**CITY OF ALBUQUERQUE  
PLANNING DEPARTMENT  
May 8, 2013  
DRB Comments**

**PROJECT # 1009178**

**APPLICATION # 13-70528**

**RE: Lot 31, Block 9, Volcano Cliffs Unit 18**

SKETCH PLAT
TIBURON HEIGHTS
 WITHIN THE
 CITY OF ALBUQUERQUE
 BERNALILLO COUNTY, NEW MEXICO
 OCTOBER, 2012

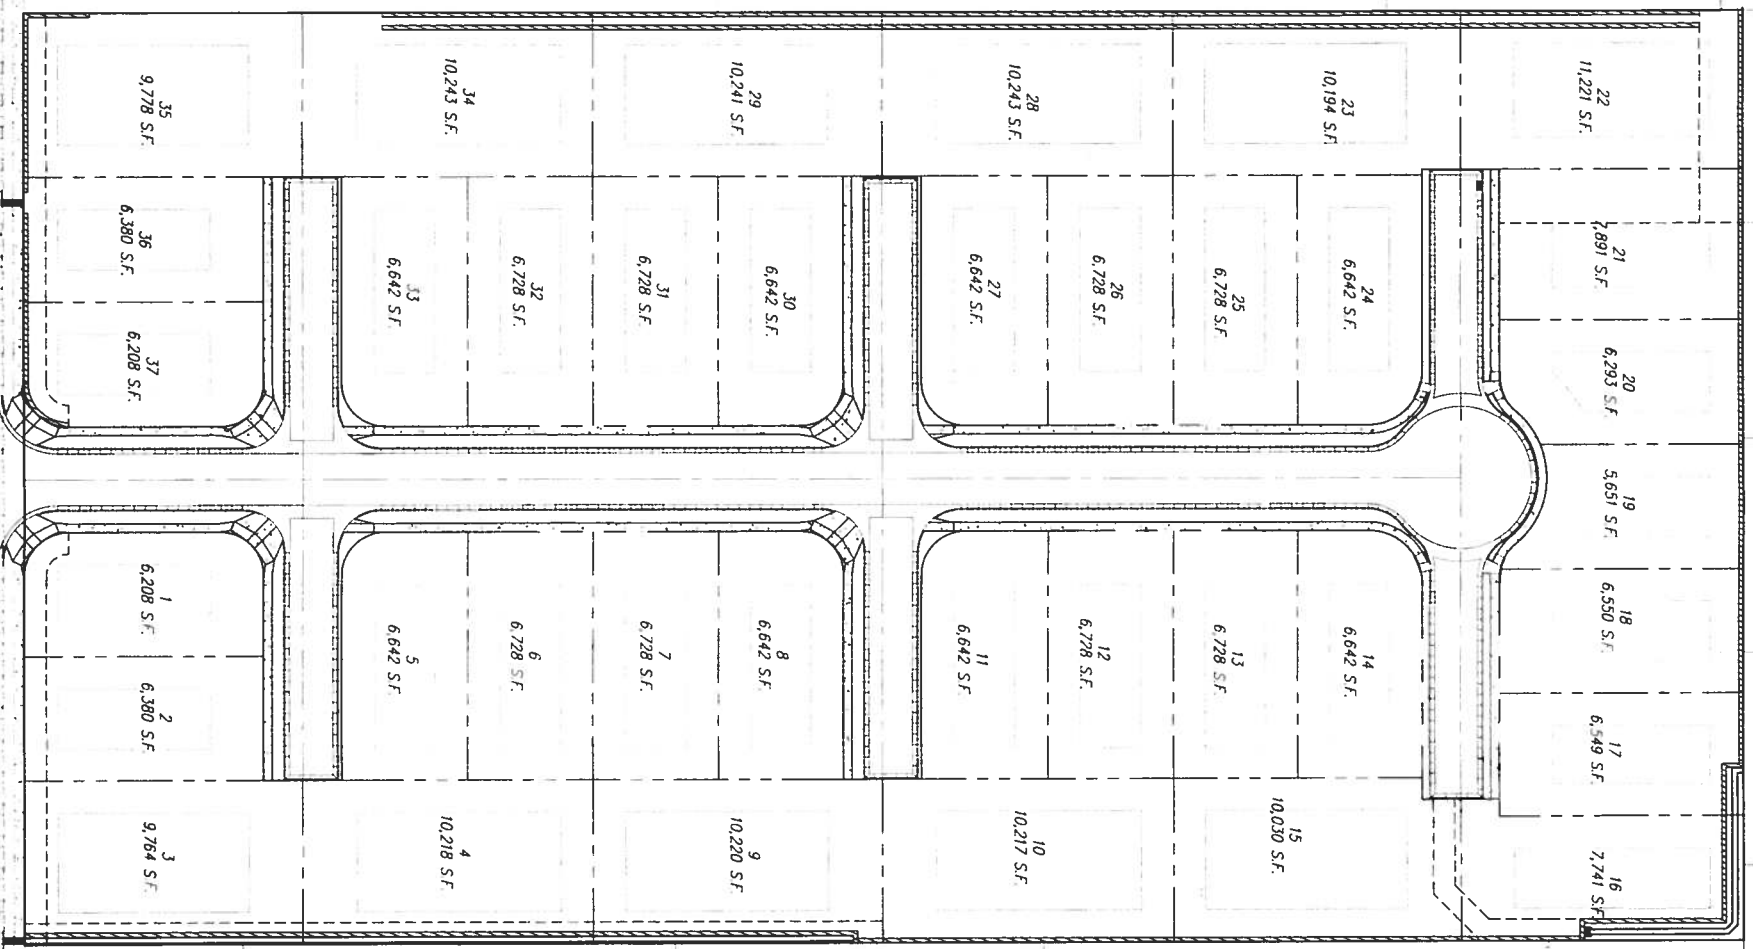
An alternative layout is needed in order not to create single loaded streets and provide for orderly and harmonious development. Given the exceptional physical characteristics of this property, variances to the setbacks could be pursued to allow more shallow lots without significantly altering the footprints.

Proposed streets do not meet Transportation Regulations of the sector plan for 52' ROW width.
